NORFOLK BOREAS OFFSHORE WIND FARM

Planning Inspectorate Reference: EN010087

**Natural England's response to
DCO documents**

29th April 2020

Relationship of Pre-commencement Plans secured by the DCO and DML's

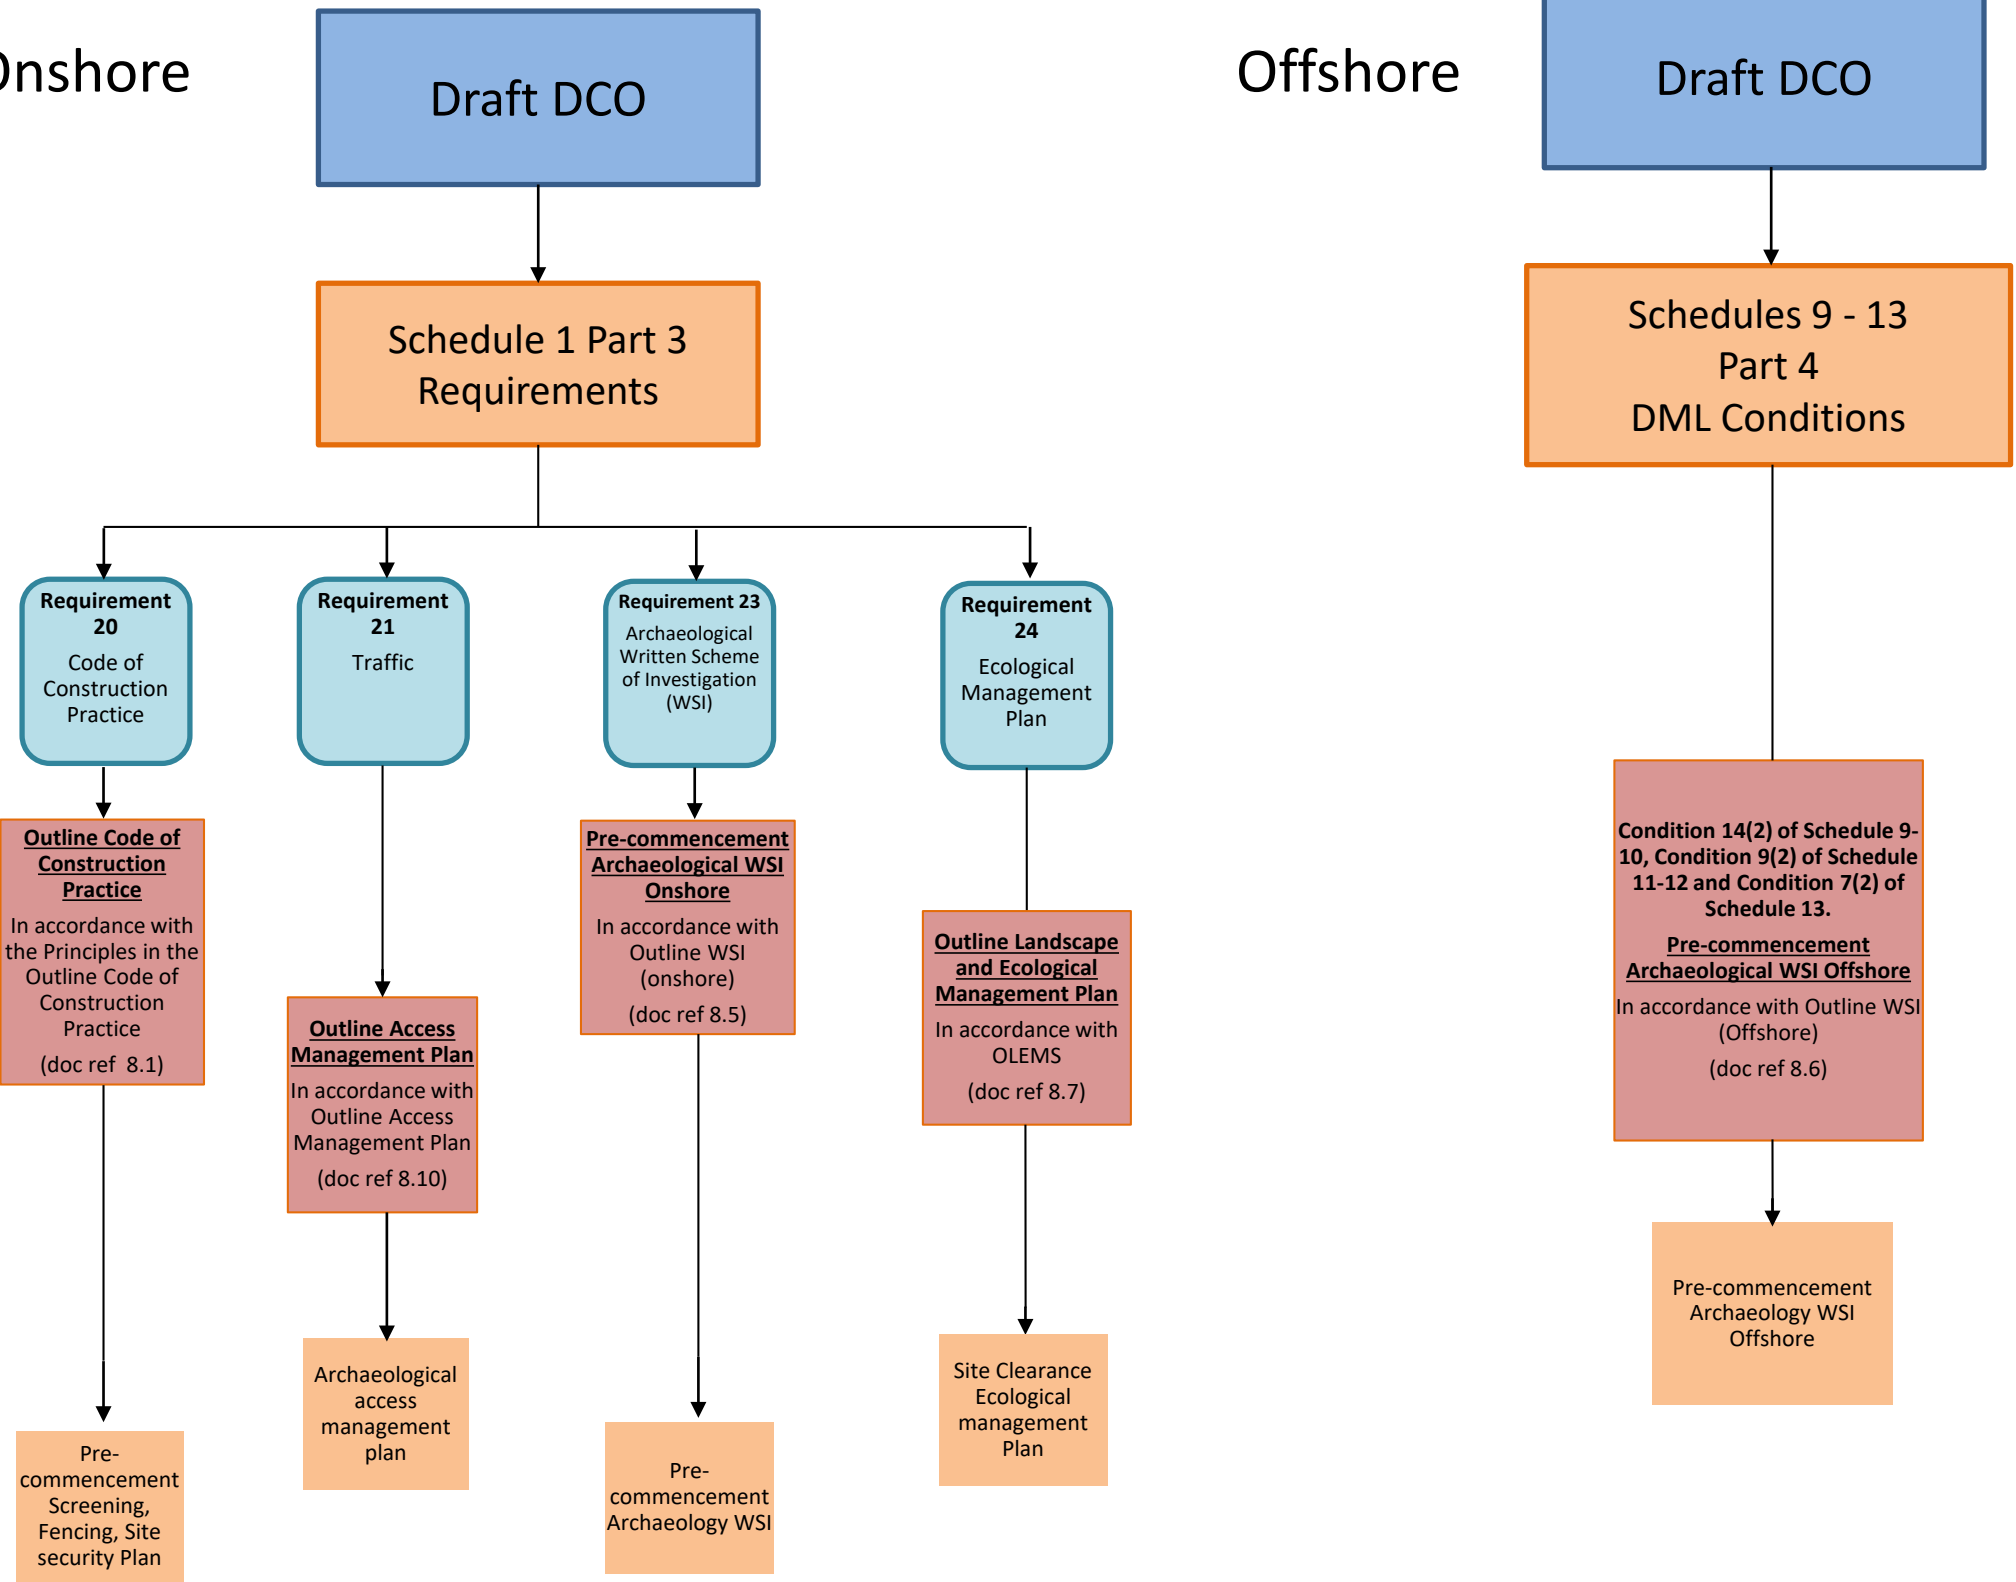
3.3 Note on Requirements and Conditions in the Development Consent Order [REP5-005]			
Annex 1 Diagram 2		<p>On the diagram showing Relationship of Pre-commencement Plans secured by DCO and DMLs, for the offshore section. Natural England considers that reference should be made here to the requirements to submit monitoring methodologies, including the new proposed plan for ornithological monitoring aims and objectives to be submitted</p>	
Schedule of Changes to the draft Development Consent Order [REP7-014]			
Point 68		<p>Natural England welcomes the change; however, as advised in our response to ExA 3rd round of written questions, we note that the minimum turbine size of 11.55MW should also be secured within the table.</p>
